# CITY OF ALBUQUERQUE

August 27, 2014

**RE: Lot 8-P-1, Rancho de Candelaria  
Grading and Drainage Plan  
Engineer's Stamp Date (8-5-14)(File: G13D023C)**

ENGINEER'S SEAL	LOT 8-P-1 RANCHO DE CANDELARIA	DRAWN BY JDG
DAVID SOULE 14522 REGISTERED PROFESSIONAL ENGINEER	GRADING AND DRAINAGE PLAN	DATE 08-04-2014
8/5/14	Rio Grande Engineering 1606 CENTRAL AVENUE SE SUITE 201 ALBUQUERQUE, NM 87106 (505) 872-0898	SHEET # 1 OF 1
DAVID SOULE P.E. #14522		JOB #

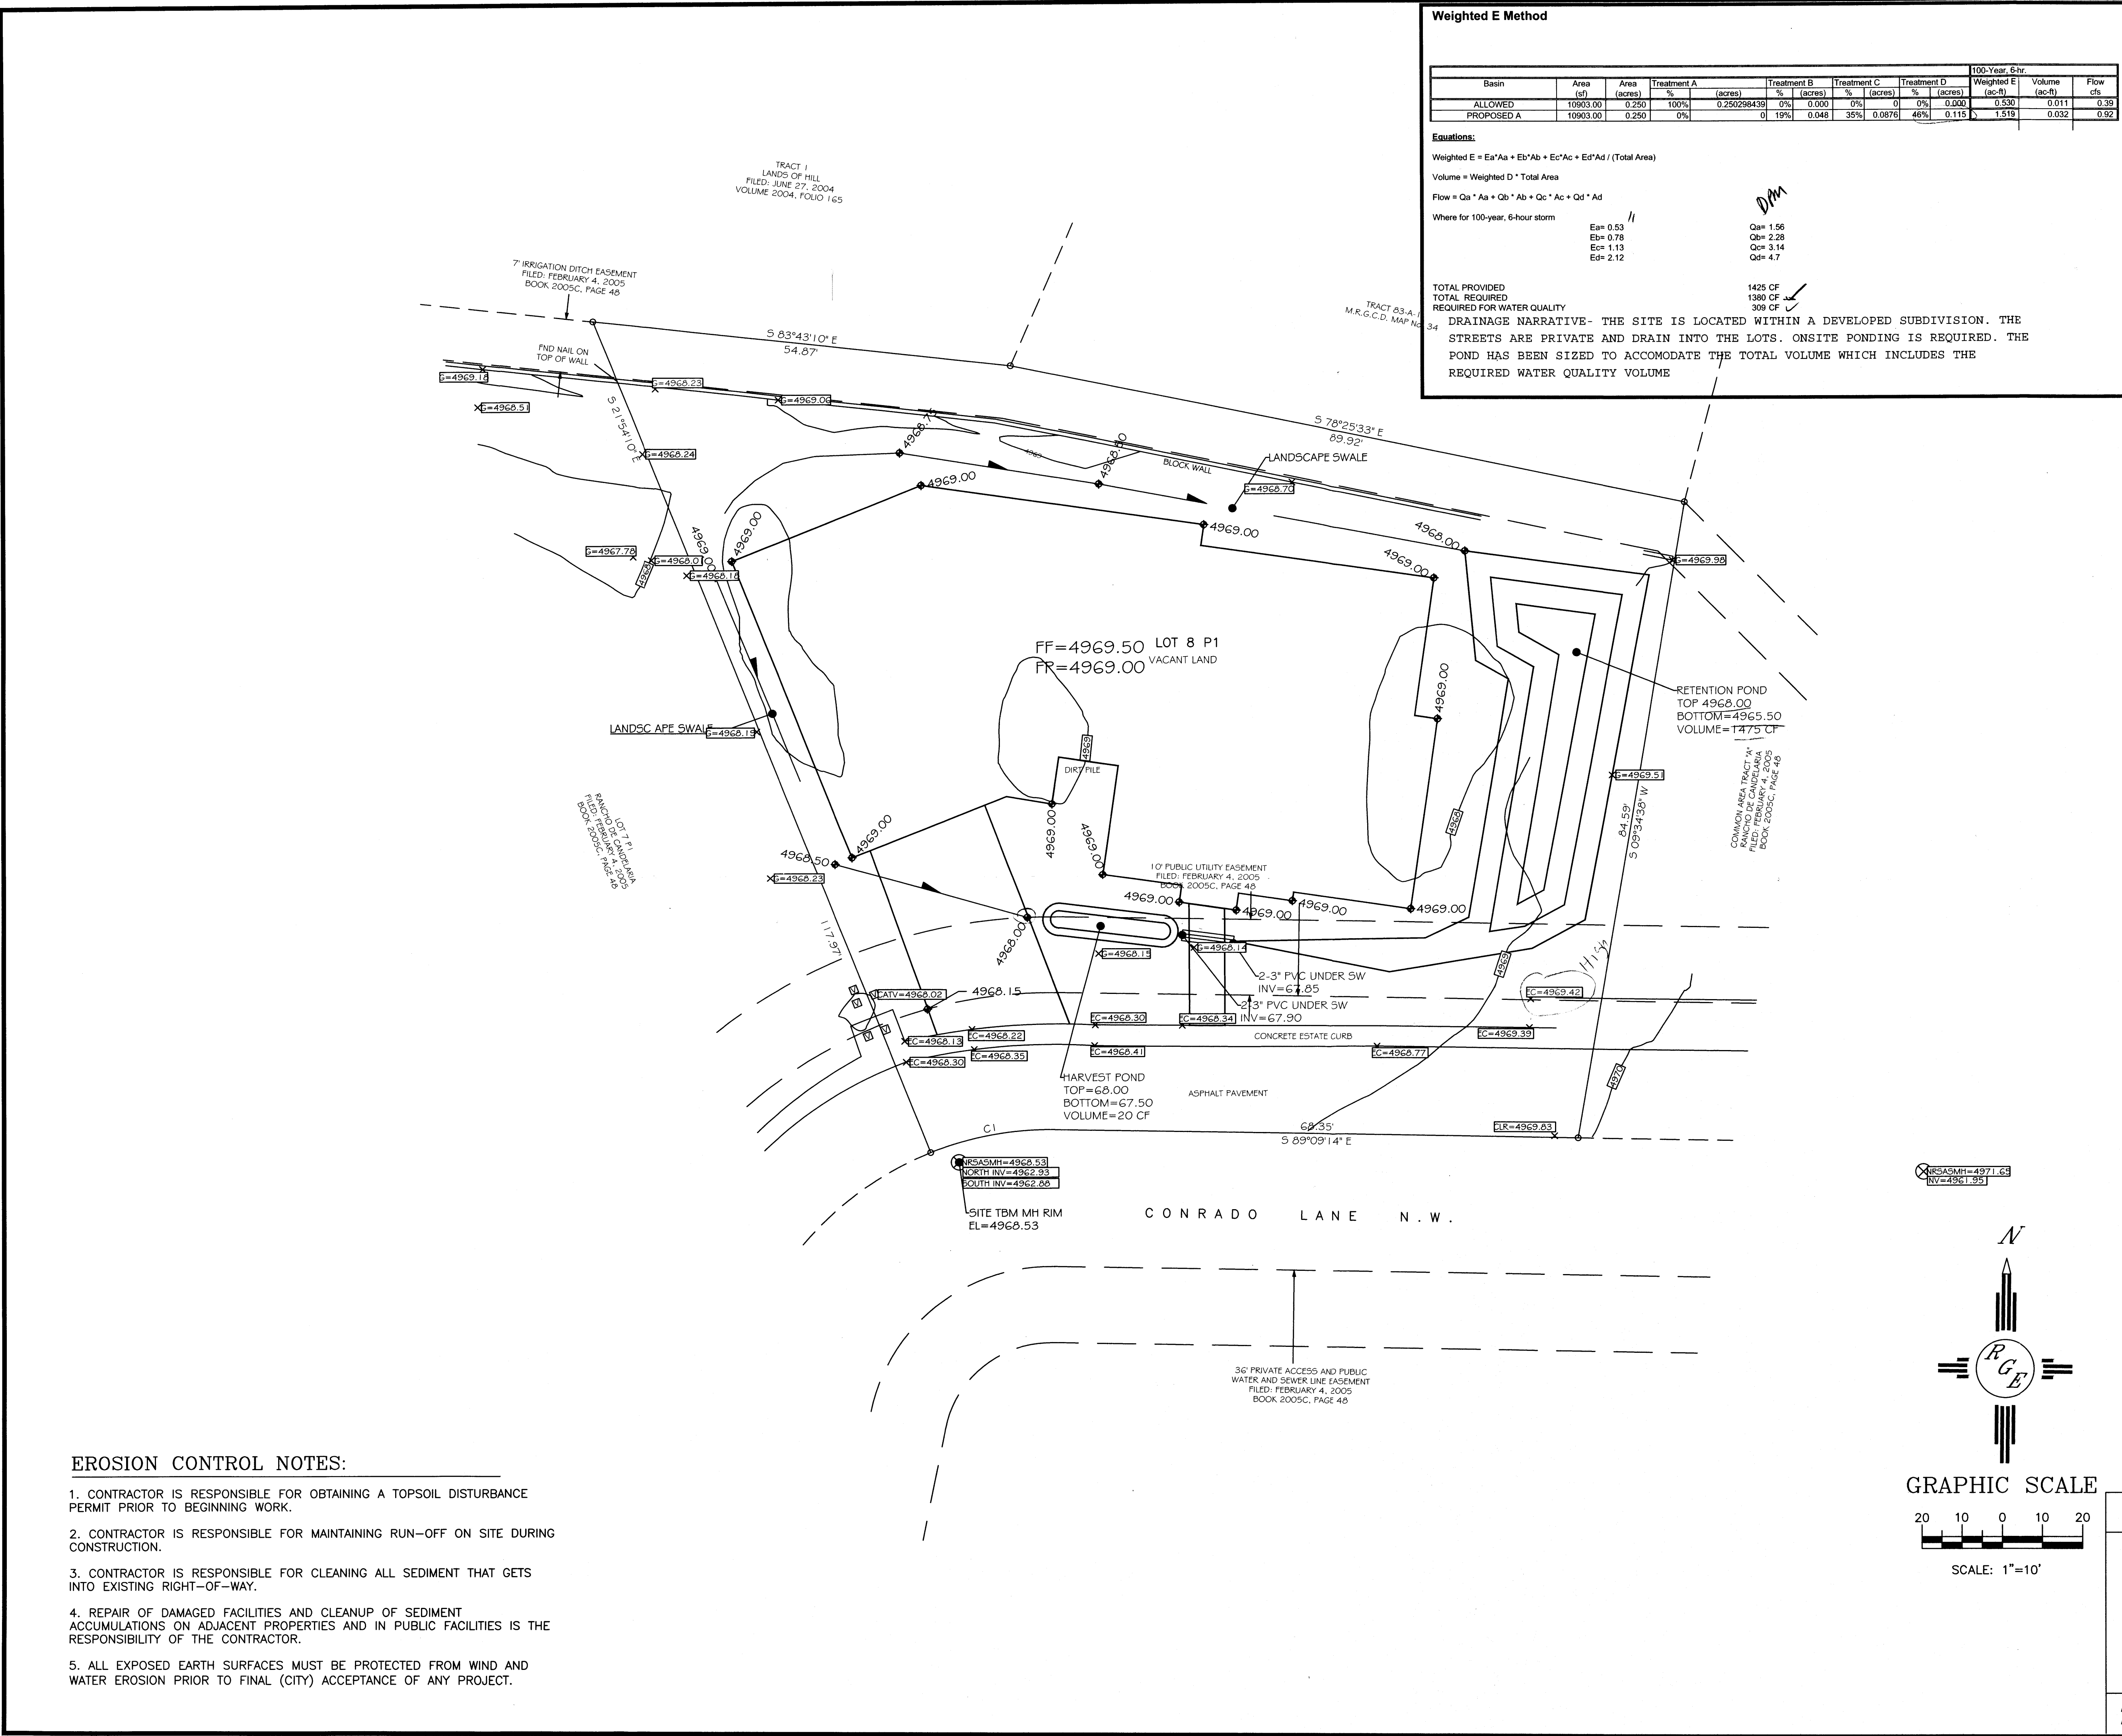
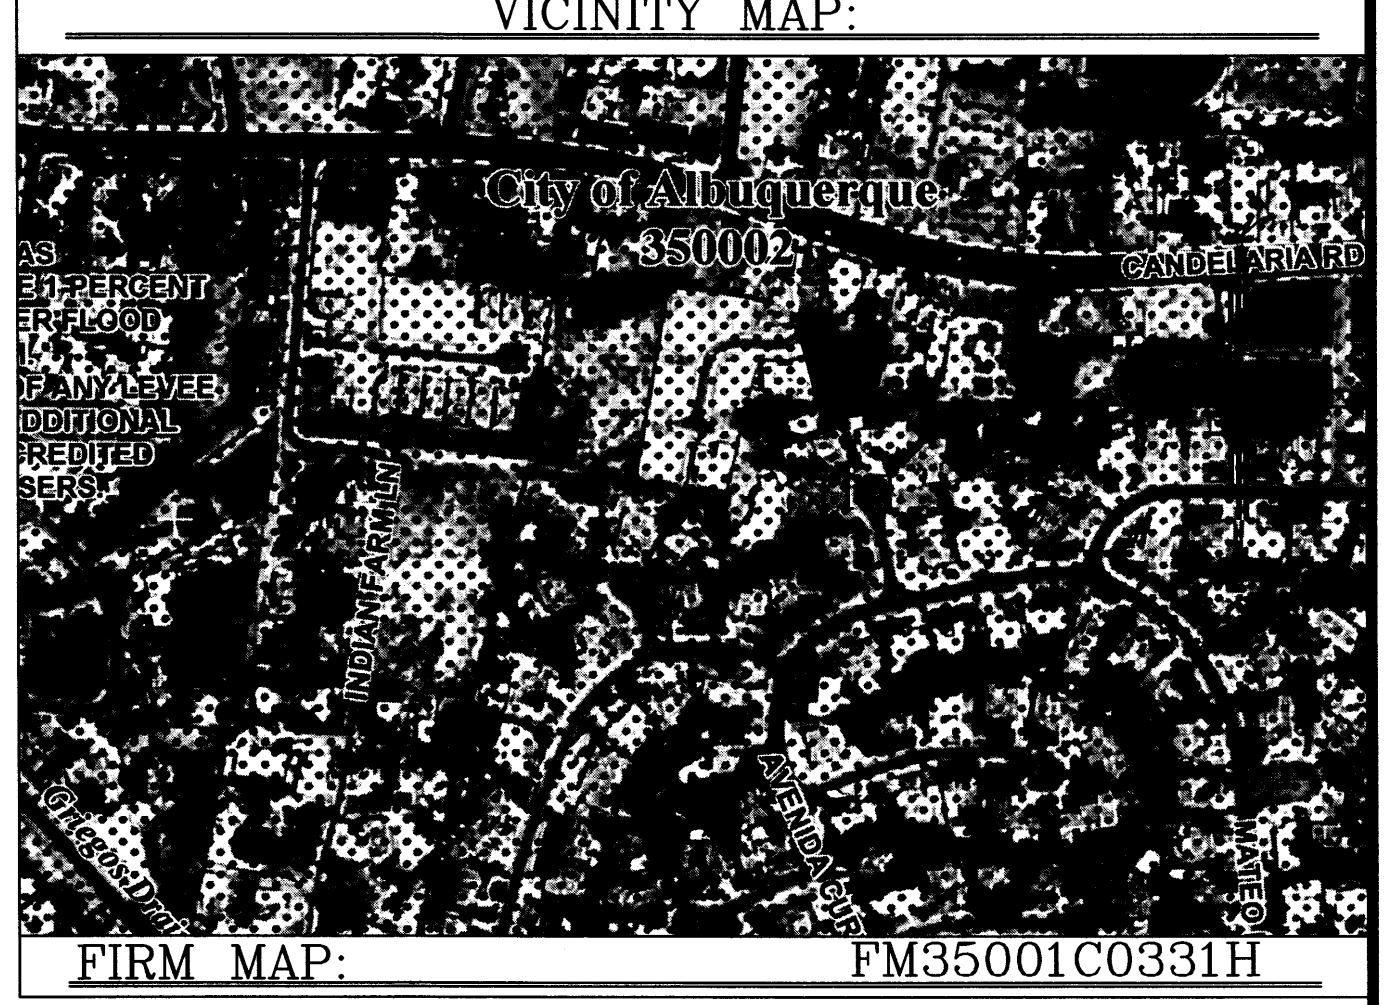
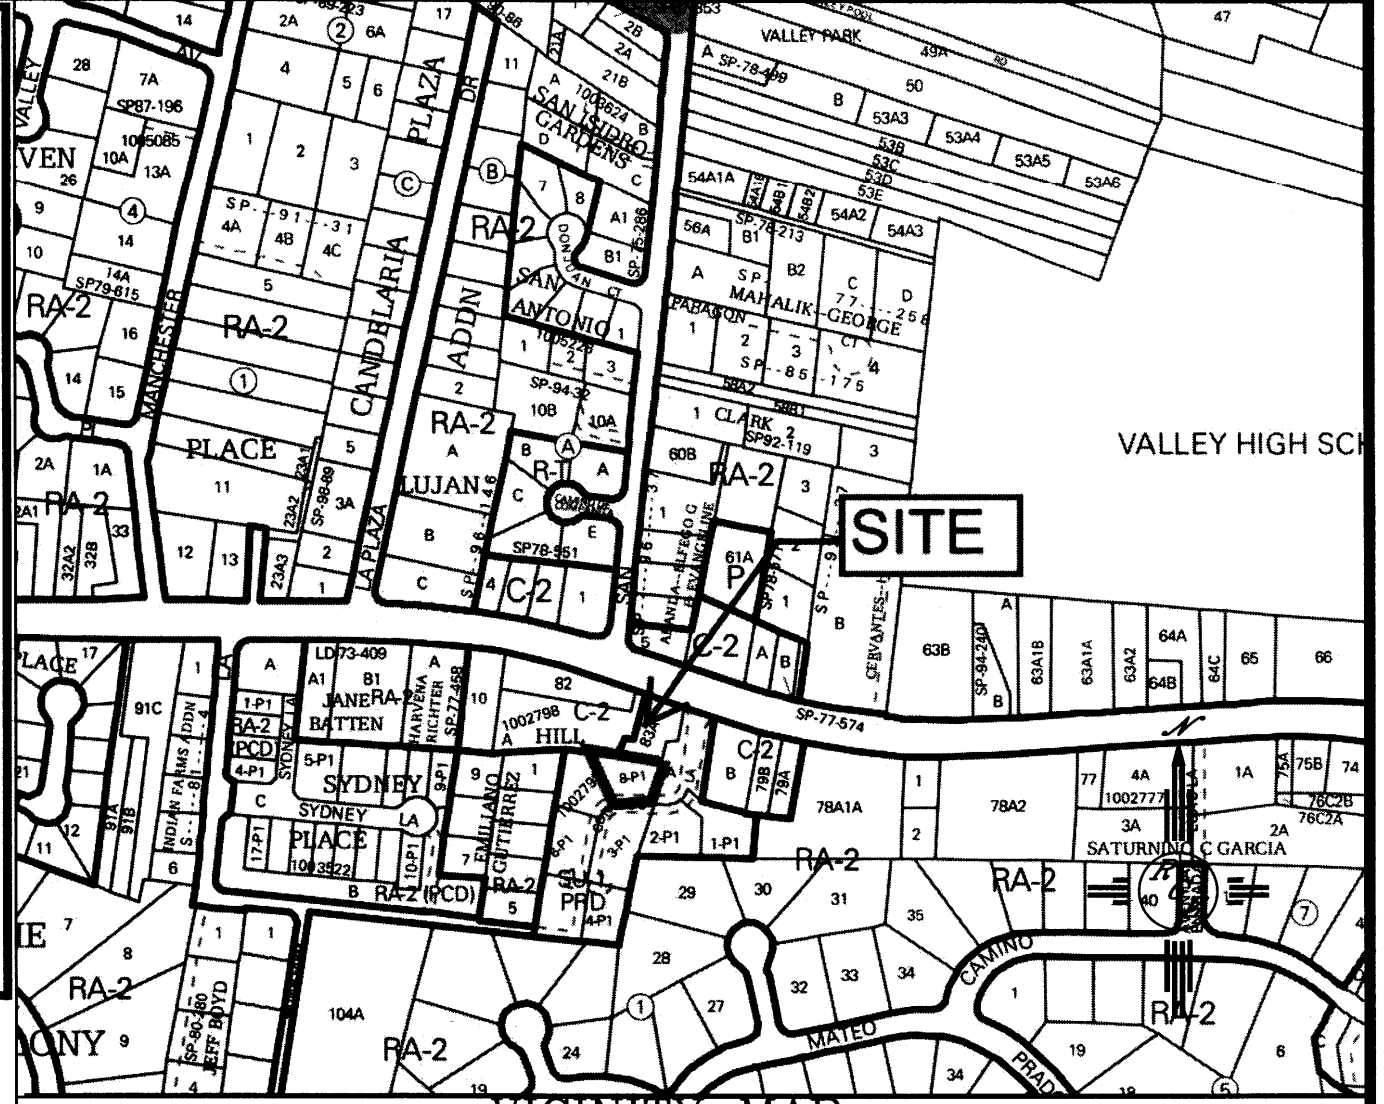
- Prior to Certificate of Occupancy, the As-built Grading and Drainage Plan must show roof, new paving, and roadway along frontage drain into ponds.
